# PORTLAND MAINE

December 18, 2009

RE: 55 (59) Washington Avenue – 013 I043 – B-4 – Signs for Electrical Wholesalers – permit #09-1134

Blade Sign

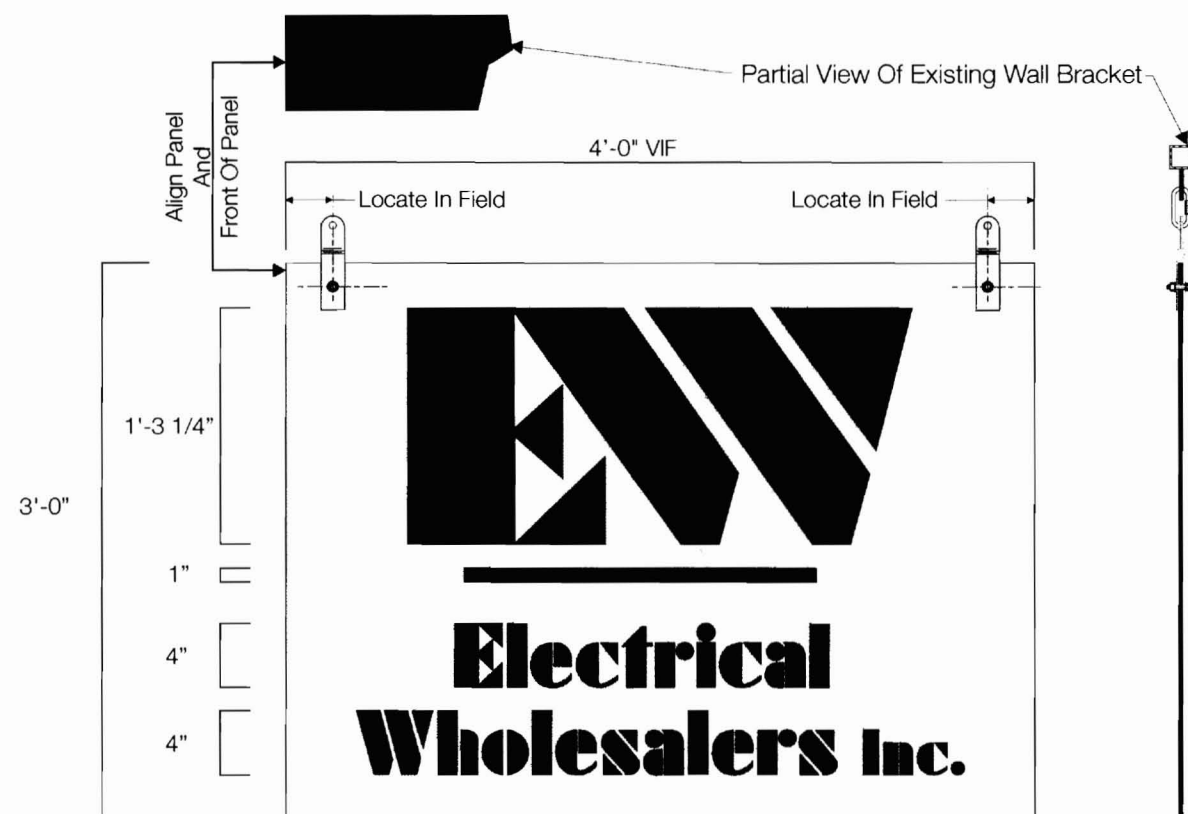
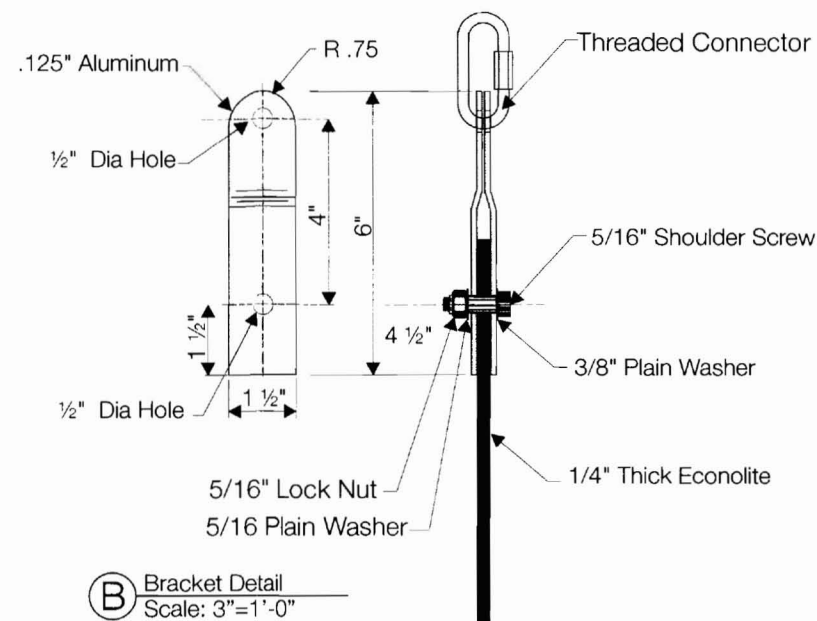
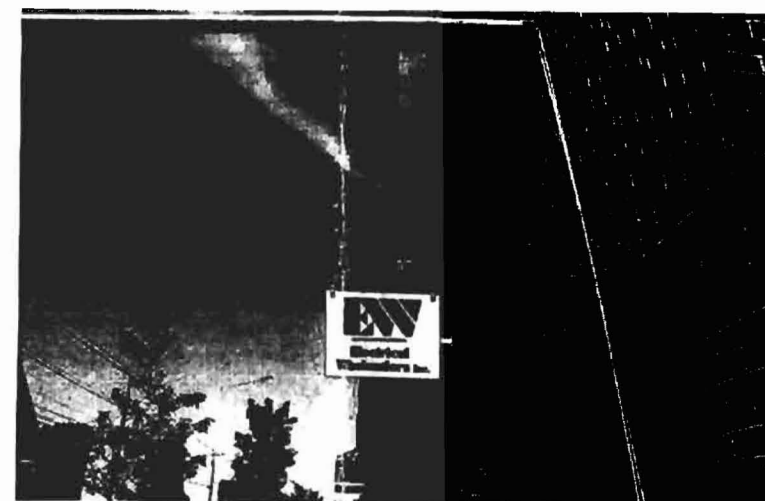
I spoke to you at the counter on November 19, 2009. You had revised the application requesting to install two signs, the 3' by 4' sign hanging perpendicular to the building and the 2.5' x 20' sign over the bays. I left you a voicemail on November 20, 2009 telling you that only one sign can be permitted under the ordinance. I have not heard from you since.

I drove by 55 Washington Avenue yesterday morning, December 17, 2009, and saw that the 3' x 4' hanging sign had been installed, and there was a sign over the bays and a sign on the side wall that connects the front of the tenant space to the bays. These signs are illegal because they have not been permitted. The property needs to be brought into compliance. You need to either appeal my decision or decide which sign you want to

keep, permit that sign and remove the other two. You have fourteen days from the date of this letter to either appeal my decision or permit one sign and remove the other two.
